APPLICATION BE/180/16/PL

Site Address: Land adj to 2 North Bersted Street Bognor Regis PO22 9AD

**ADC Planning Consultation
Response from the Historic Buildings Adviser**

Application Number	BE/180/16/PL
Address	Land adj to 2 North Bersted Street, Bognor Regis
Description	1 no dwelling.
Case Officer	Simon Davis
Site Visit

SITE PLAN
SCALE 1:200

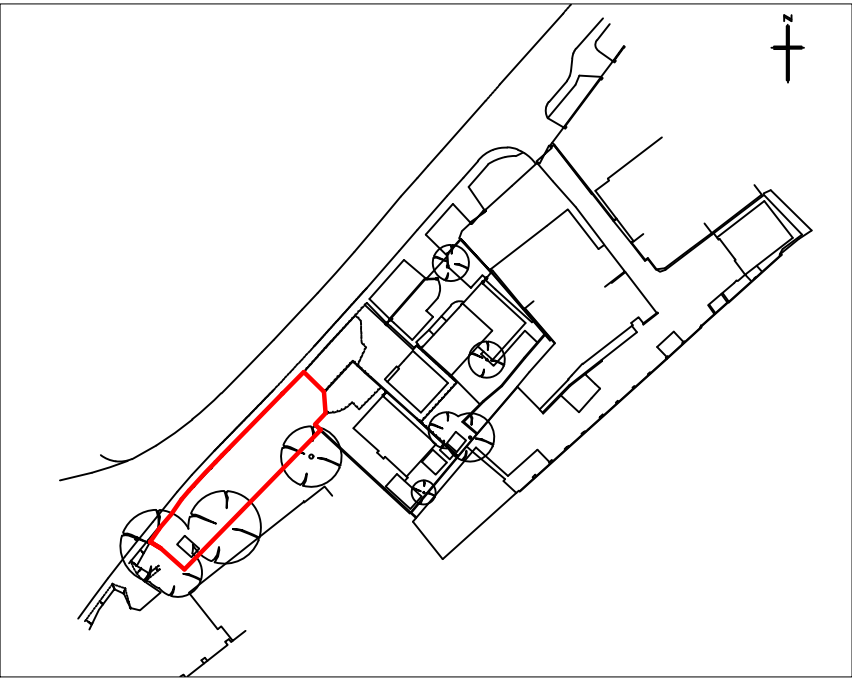
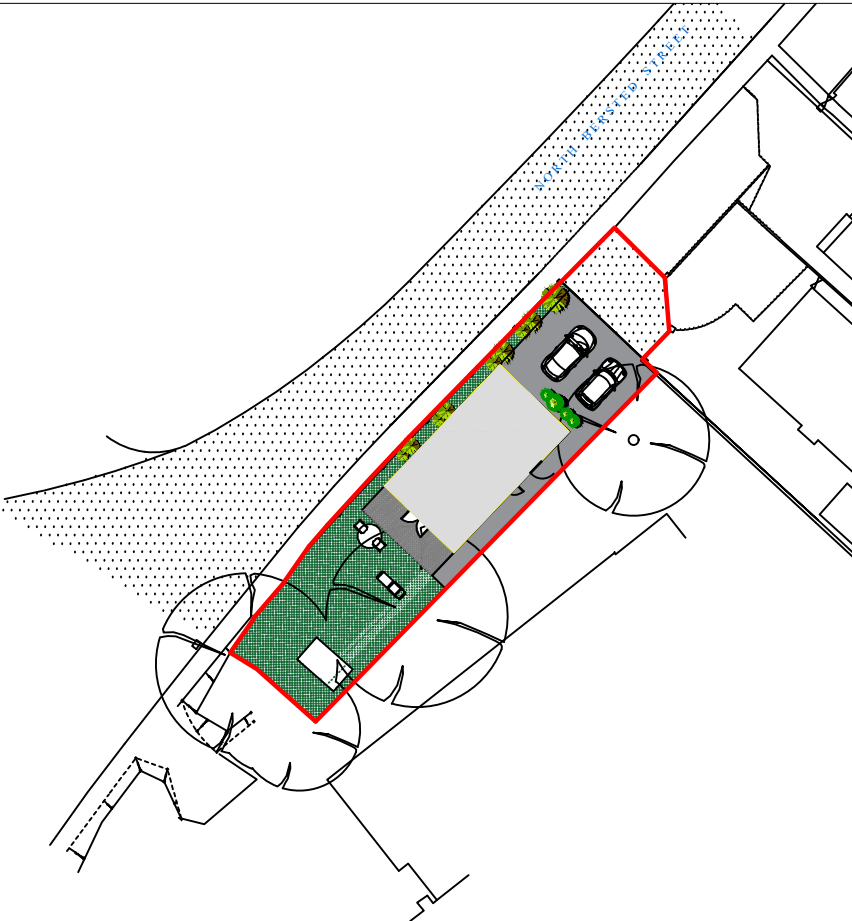
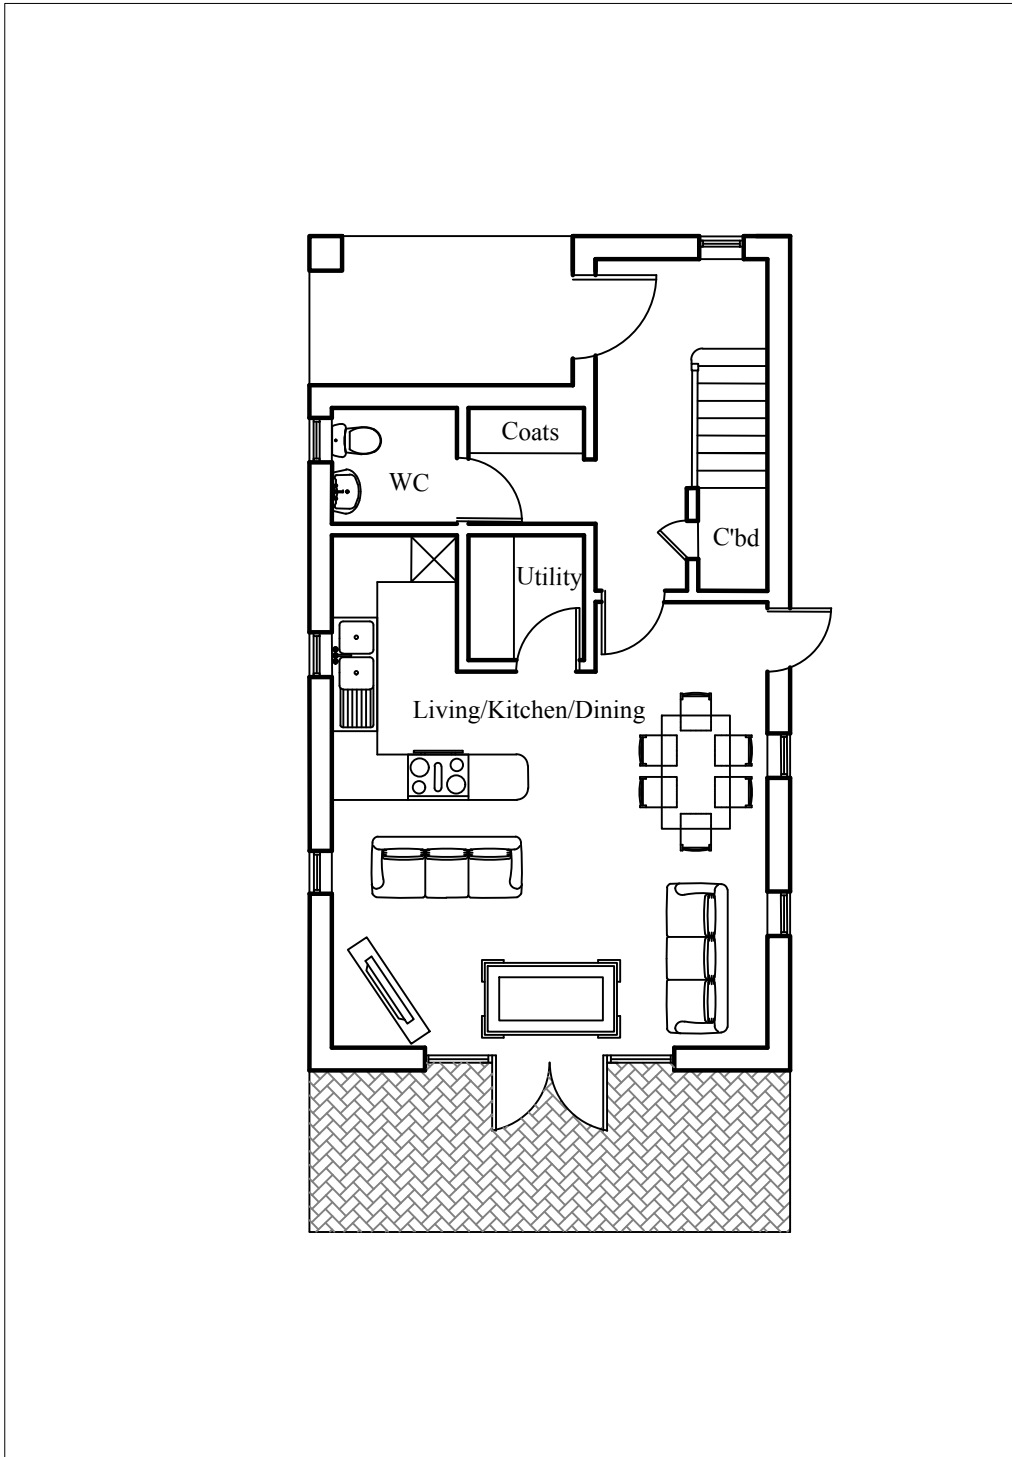
All that said, this does not negate the need to consider carefully the design. In this instance, the house is situated close to the pavement and road and is not set back in the same way as other dwellings. It therefore is likely to appear cramped in this regard and incongruous with the other development around it. The treatment of the façade seems to exacerbate this sense, being largely blank of fenestration at first floor level with dormers breaking through the eaves. This does not sit well in the street scene and as such must be considered negative.

Project
NORTHERSTEDSTREET
BOGNORREGIS
Drawing
ELEVATIONS&SECTION
Date
NOVEMBER2016
Drawn by
TK
Status
PLANNING
Scales
1:100@A1
Job No
TSP573
Dwg No
PL-03
Revision

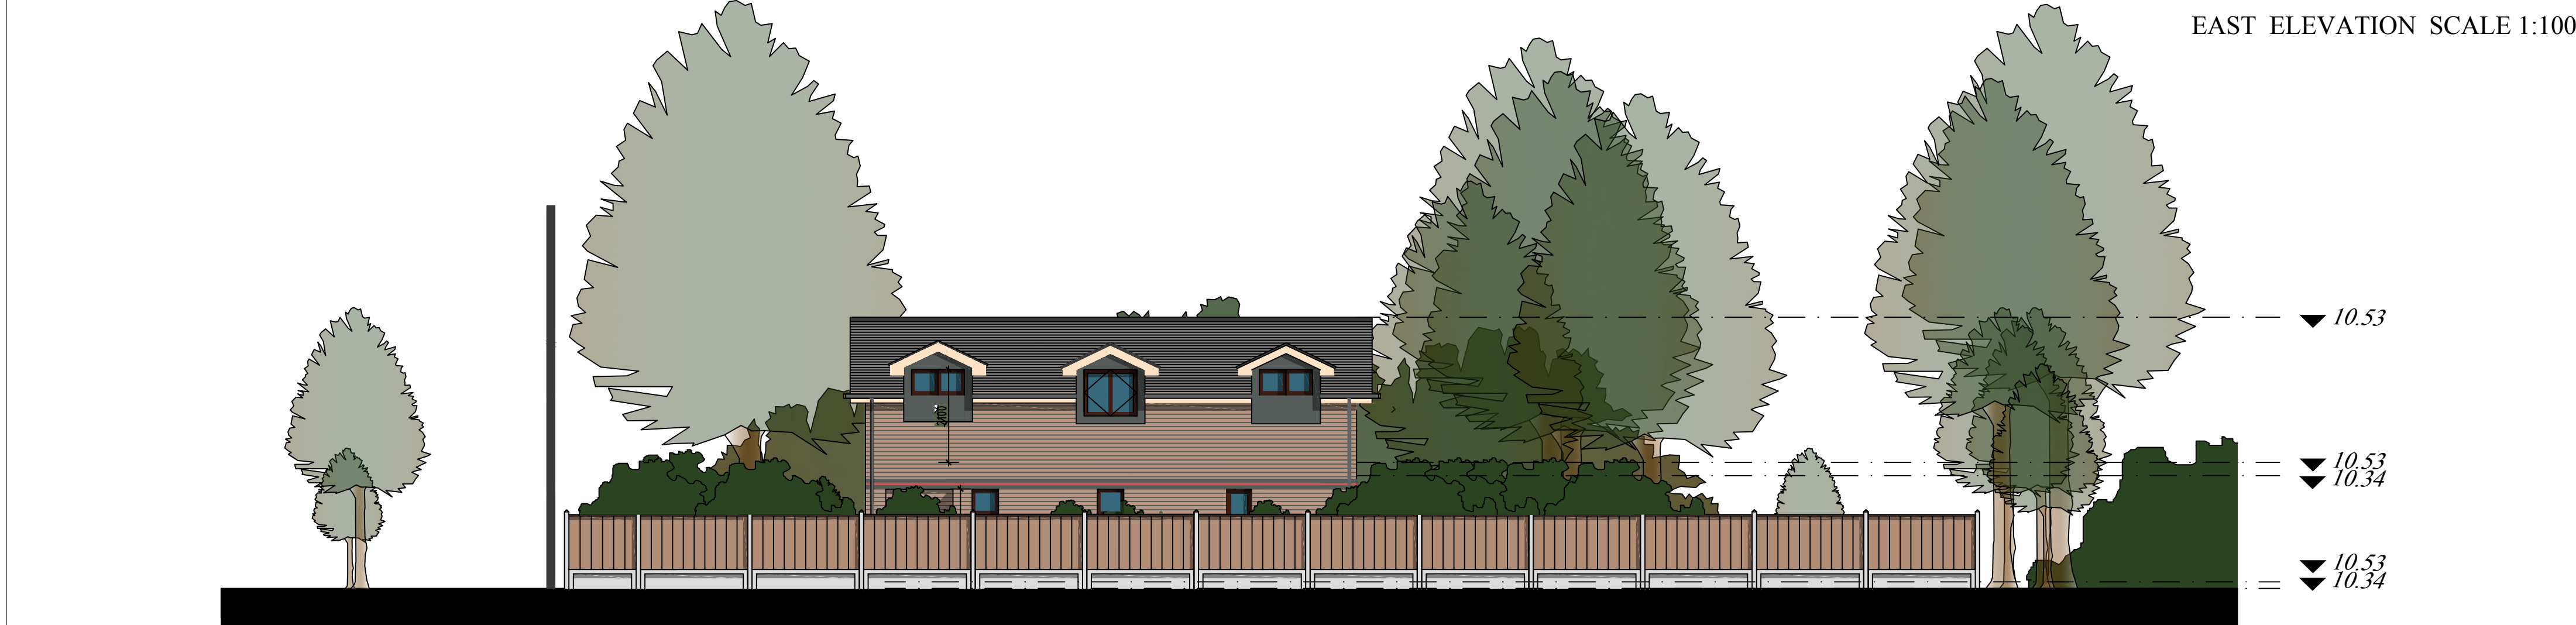
As a result I would question both its appropriateness and amenity within the street scene and suggest that further design advice is sought.
